APPLICATION FOR: 17611/APP/2022/993

42 FIELD HEATH ROAD HILLINGDON

Item No. **Report of the Interim Director of Planning, Regeneration & Public Realm**

Development: Demolition of a two-storey bed and breakfast, and the erection of a three-storey residential development comprising of seven flats, alterations to existing drop kerb, all associated external works and landscaping.

| .            | 555/B/03                                 | .         |          |

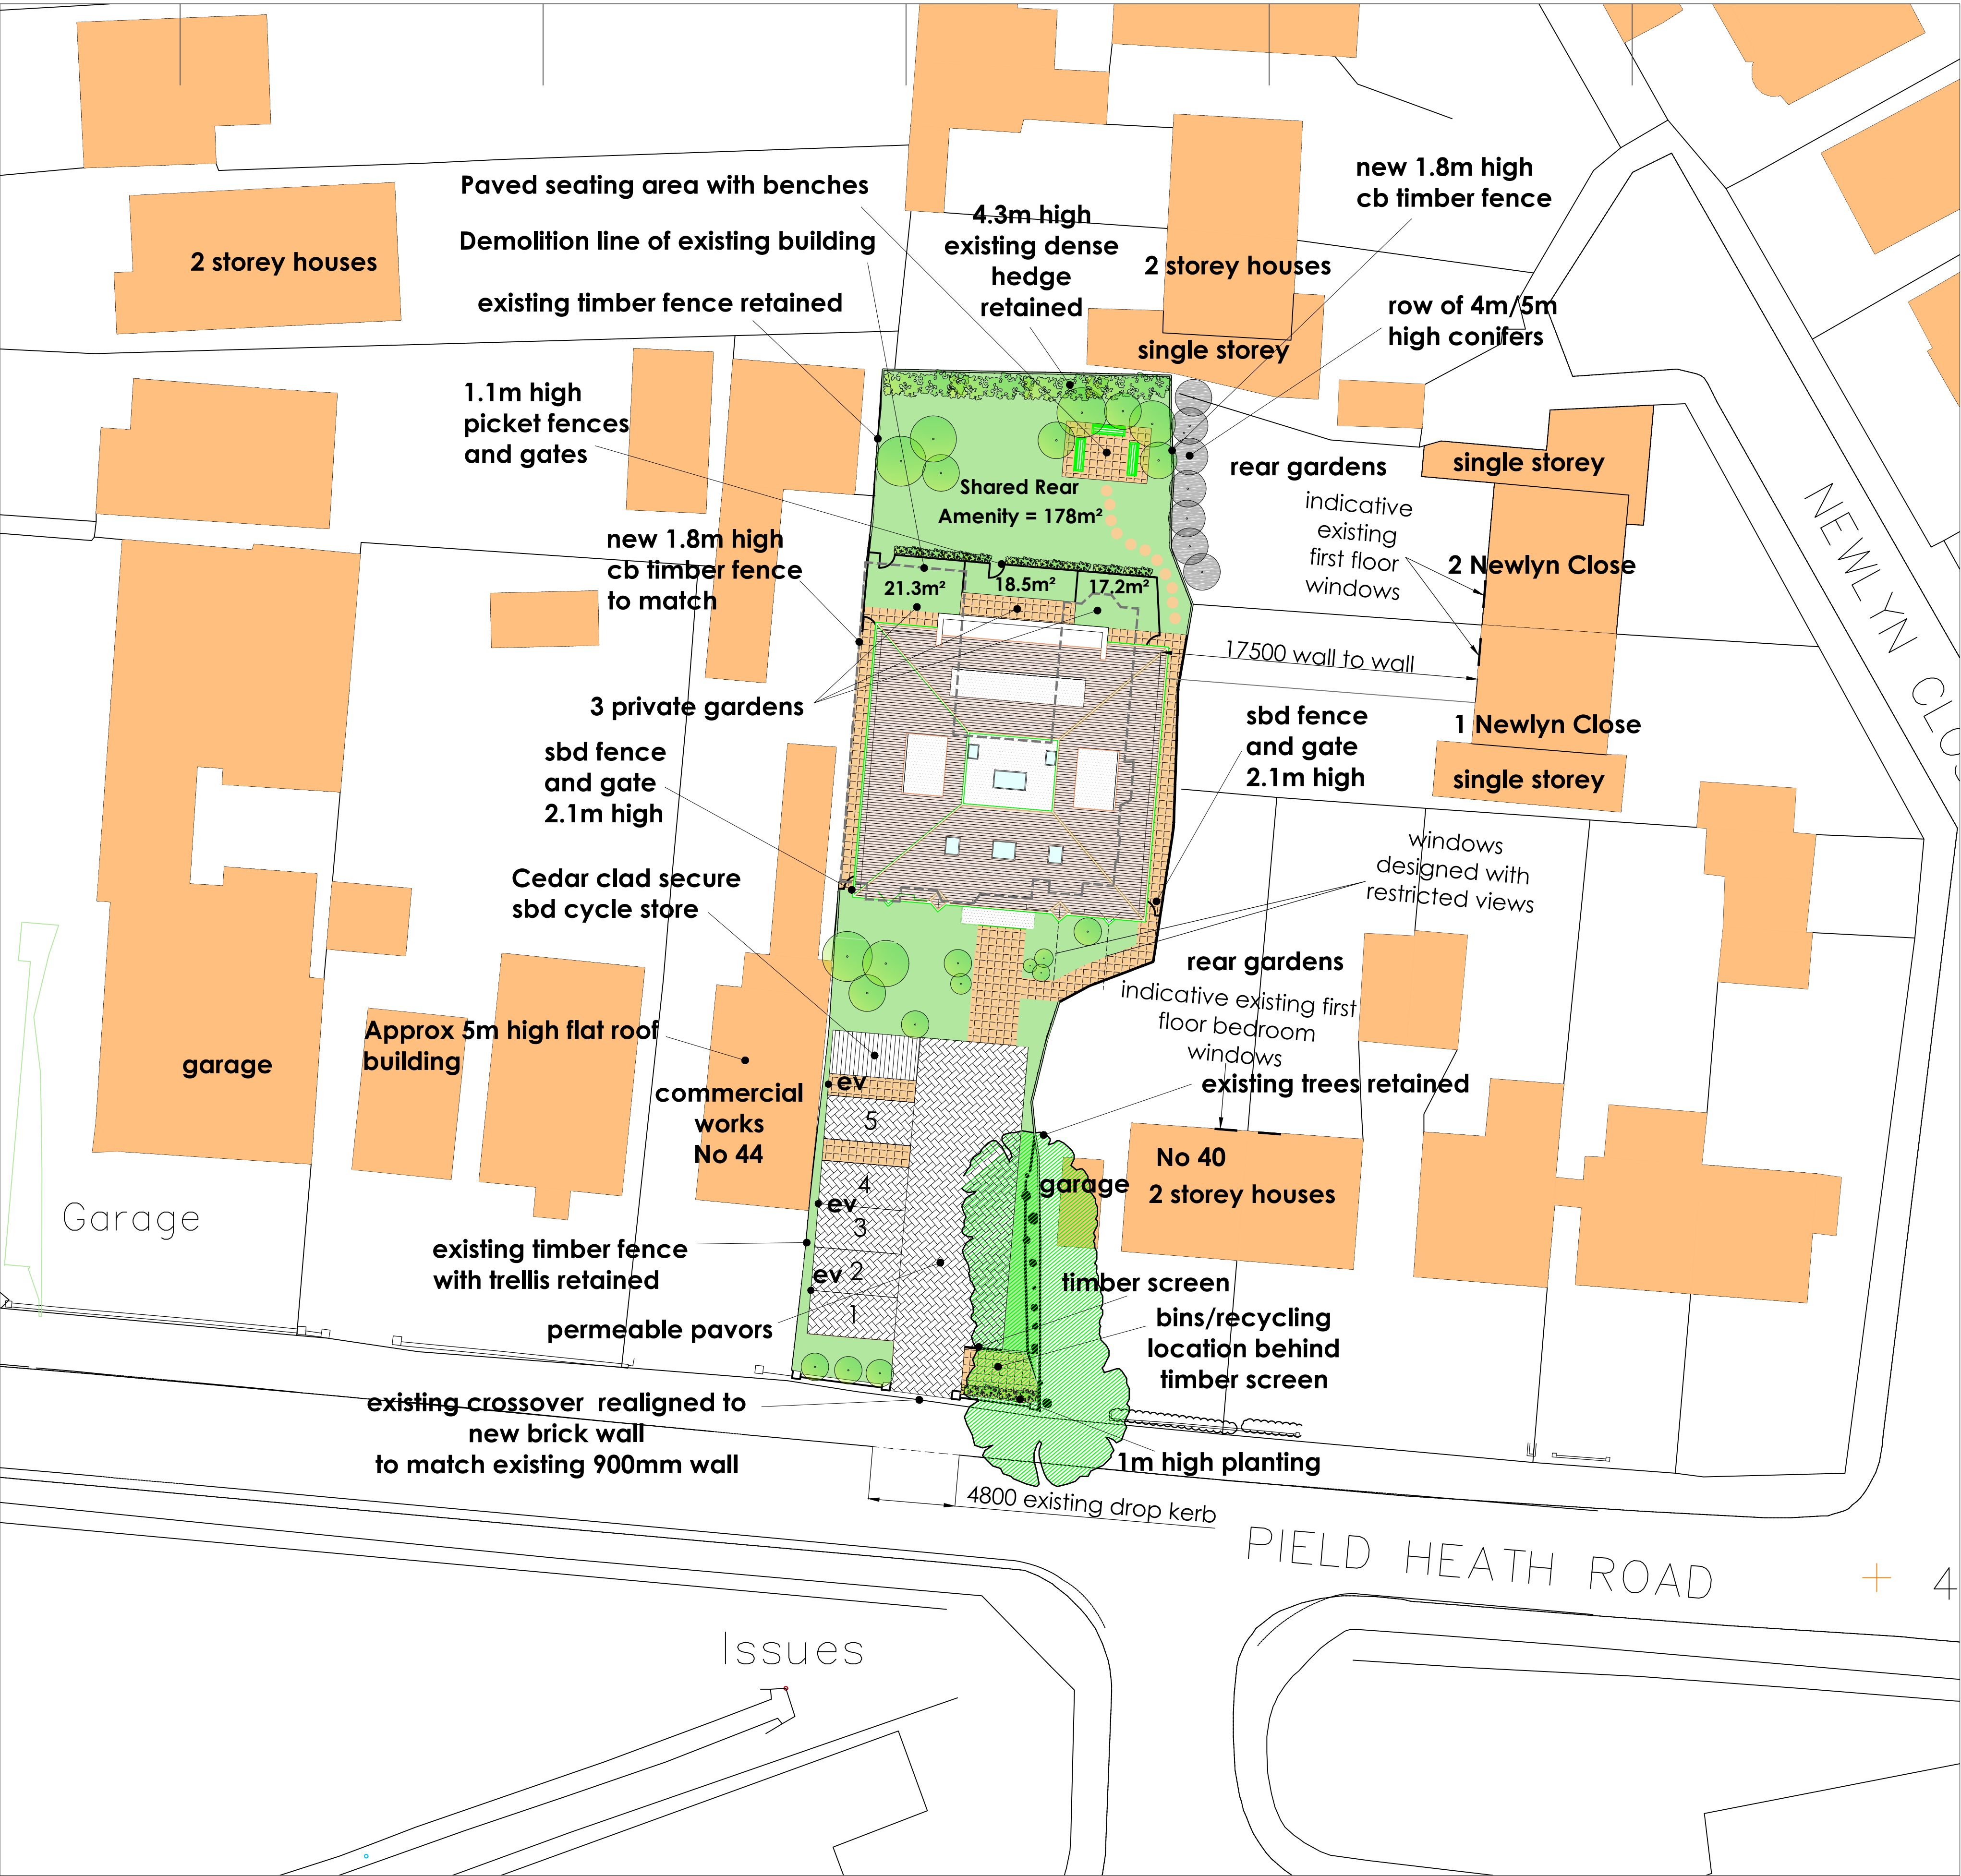
42 Pield Heath Road will utilise the existing vehicle crossover, with some changes being made to it. However, the development wishes to introduce a 1-metre-high planting to the east and realign the wall to a new 900mm wall.

This would be too high and would block line of sight for vehicles exiting the site, which presents safety concerns for pedestrians from exiting vehicles. This is in breach of the published London Borough of Hillingdon's Domestic Vehicle Footway Crossover policy June 2022 which states that 'fences, walls and shrubs should be kept to a maximum height of 0.6m' and the published London Plan Policy T4 Assessing and mitigating transport impacts which states that 'development proposals should not increase road danger'.

As mentioned above the development will be on-site cycle storage parking for the residents. However, the submitted site plan dated 10/09/2022 makes no mention of the quantity that will be provided, which makes an accurate assessment difficult to do. For a development of this type to be within policy at least 12no. would need to be provided. Therefore, this proposal contradicts the London Plan 2021 Policy T5 Cycle which requires to developments 'provide the provision of appropriate levels of cycle parking which should be fit for purpose, secure and well-located and be in accordance with the minimum standards'.

SITE:	42 FIELD HEATH ROAD UXBRIDGE MIDDLESEX UB8 3NP	
SCALE BAR:	 0 1 2 4 6 8 10m	
DESCRIPTION:	PROPOSED FLOOR PLANS & ROOF PLAN	
SCALE:	1:200 @ A3	DATE: SEPT 2022
DRAWING NO.:	555/B/06	REV

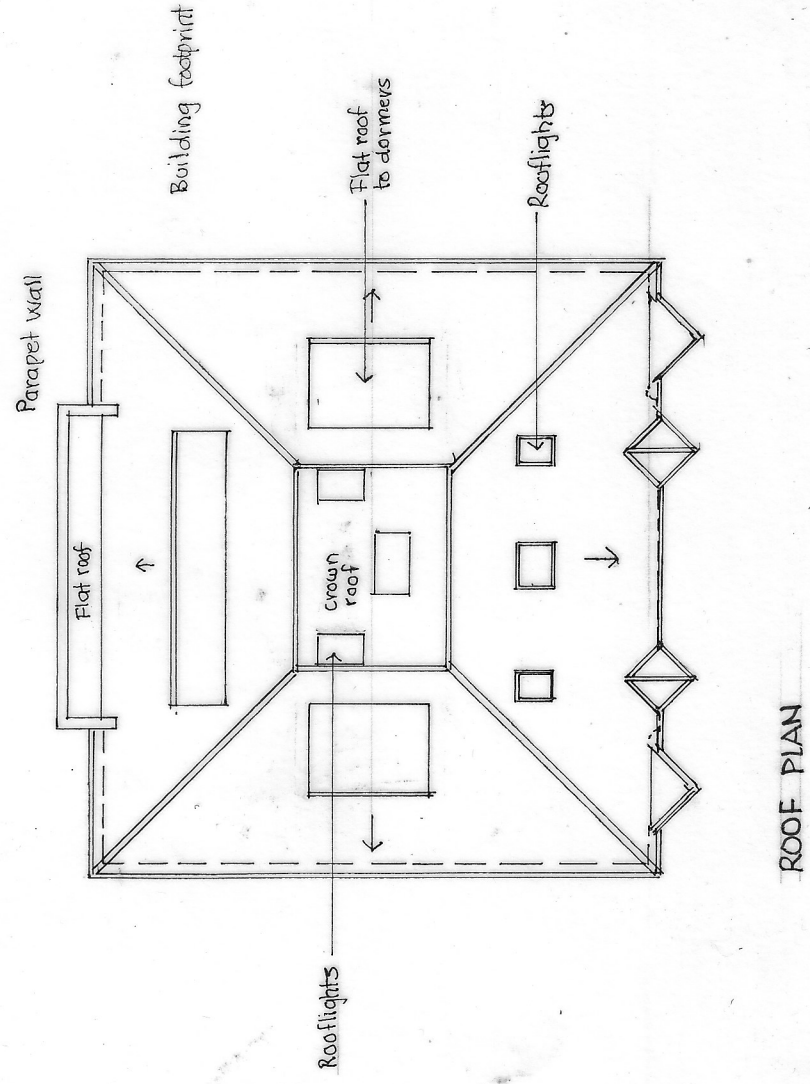
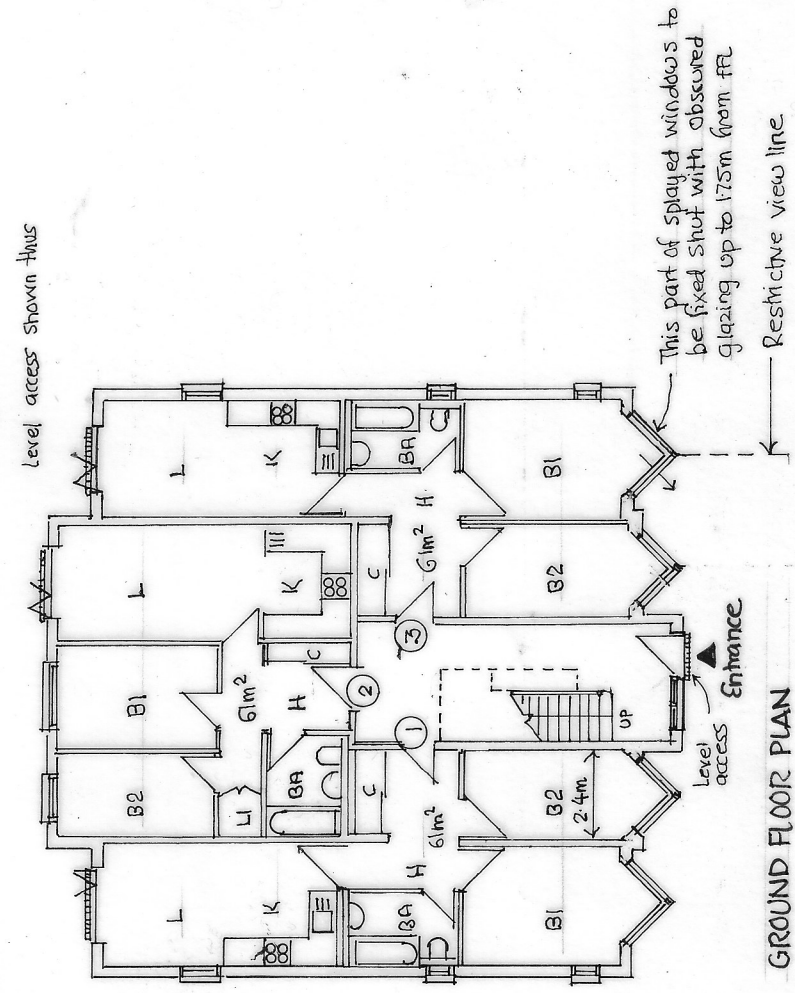
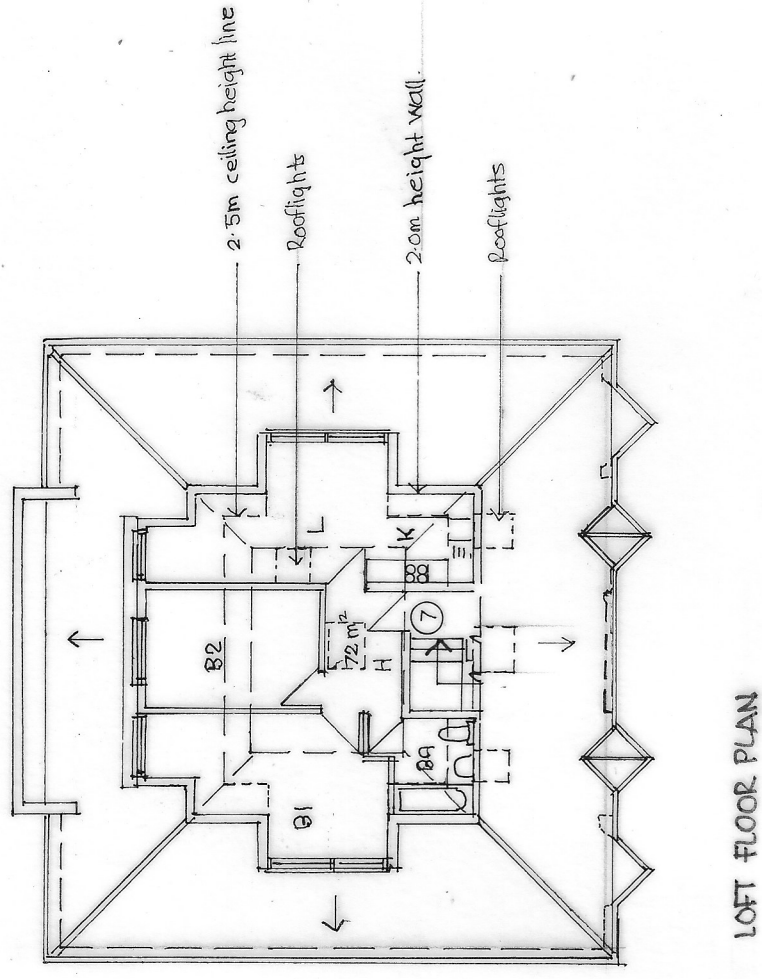
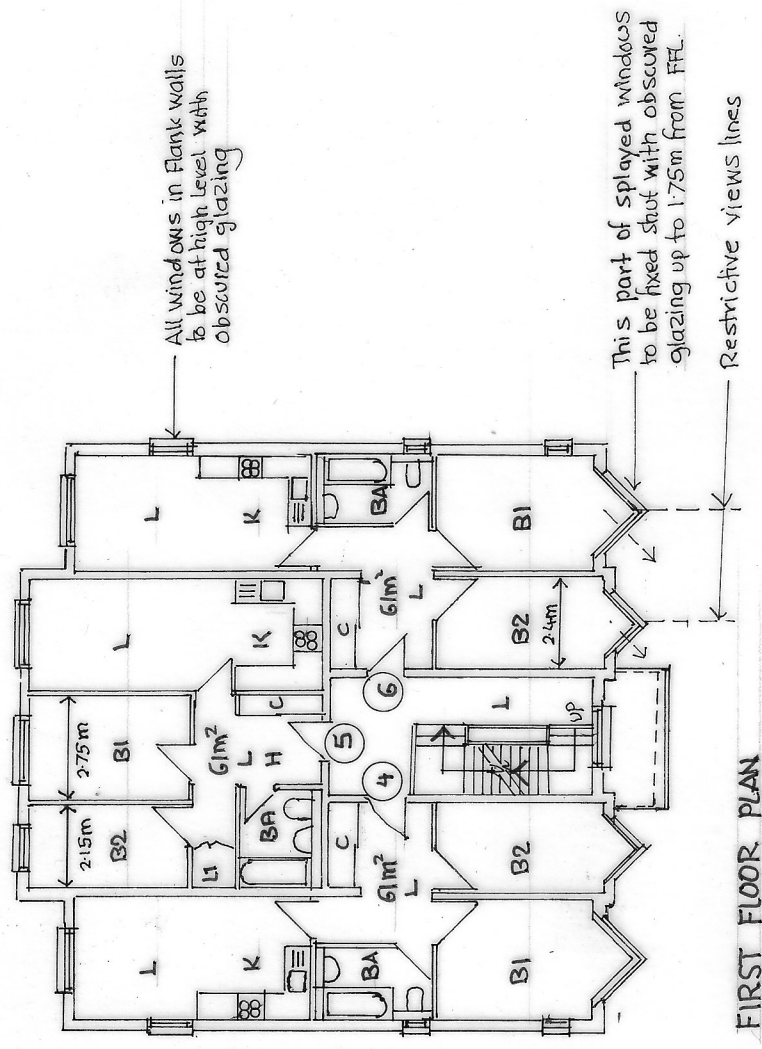
In response to point 14, the proposed floor plans show a green roof and solar panels. However the floor plans do not match the proposed roof plan. Had the application been recommended for approval the discrepancy would have been addressed by requesting amended plans. Additionally had the application been recommended for approval, a condition would have been recommended requiring full details of the green roof and solar panels.

SITE:		42 PIELD HEATH ROAD UXBRIDGE MIDDLESEX UB8 3NG	
SCALE BAR		0 1 2 4 6 8 10m	
DESCRIPTION:		PROPOSED EAST & SOUTH ELEVATIONS	
SCALE:		1:200 @ A3	
DRAWING No:		555 / A / 07	
		SEPT 2022	
		DES

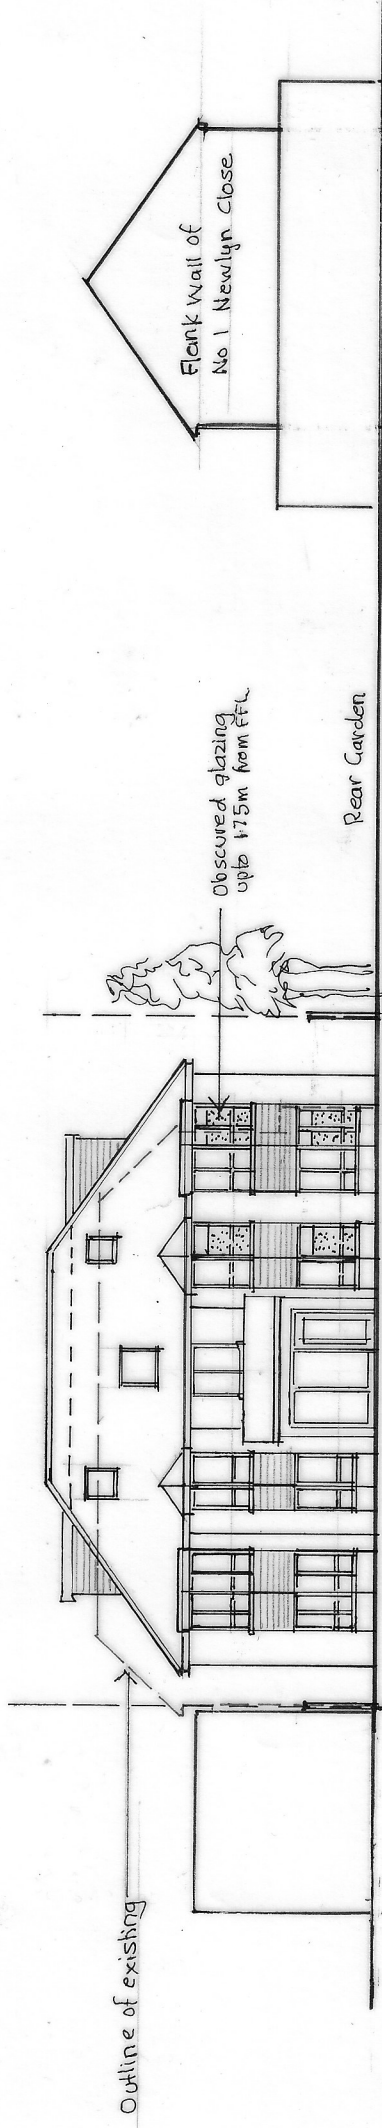
The new building would be approximately 8.8m high, 15.5m wide and 16.8m deep. It would be finished in bricks, clay tiles and upvc window and would have a stepped frontage with triangular windows, rear and side dormers and a very large crown roof. It is also worth noting that a green roof with solar panels is proposed on the submitted second floor plan, however that plan does not match the roof plan. Were the application recommended for approval, this would have been resolved or conditioned, but does not change the outcome of the assessment as a whole.

Due to its oversized footprint and associated crown roof, uncharacteristic design, siting in the plot, increased height and increased overall depth when compared with the existing building, the proposed development would be harmful and excessive in context. The building would appear as an oversized form of backland development which would harm the appearance of the street scene and wider area. As the site does not follow the area's building line, the oversized building would be visually at odds with its neighbours from multiple public and private viewpoints. Its uncharacteristic size and nature would be exacerbated by the fact that the site rises from the main road to the building, increasing the prominence of the proposed building.

The roofscape of the area is characterised by pitched roofs and this is evident in all views on and around the site. The proposed crown roof would therefore be out of character with the established roofscape of the area, adding to the bulk, massing and design concerns.

Together, the bulky crown roof, partially obscure glazed triangular bay windows, squat dormers, stepped and blocky rear elevation are considered to result in a contrived, poorly designed building, which has no similarity to other buildings in the area, making it an uncharacteristic and unsympathetic addition to the area in terms of its design.
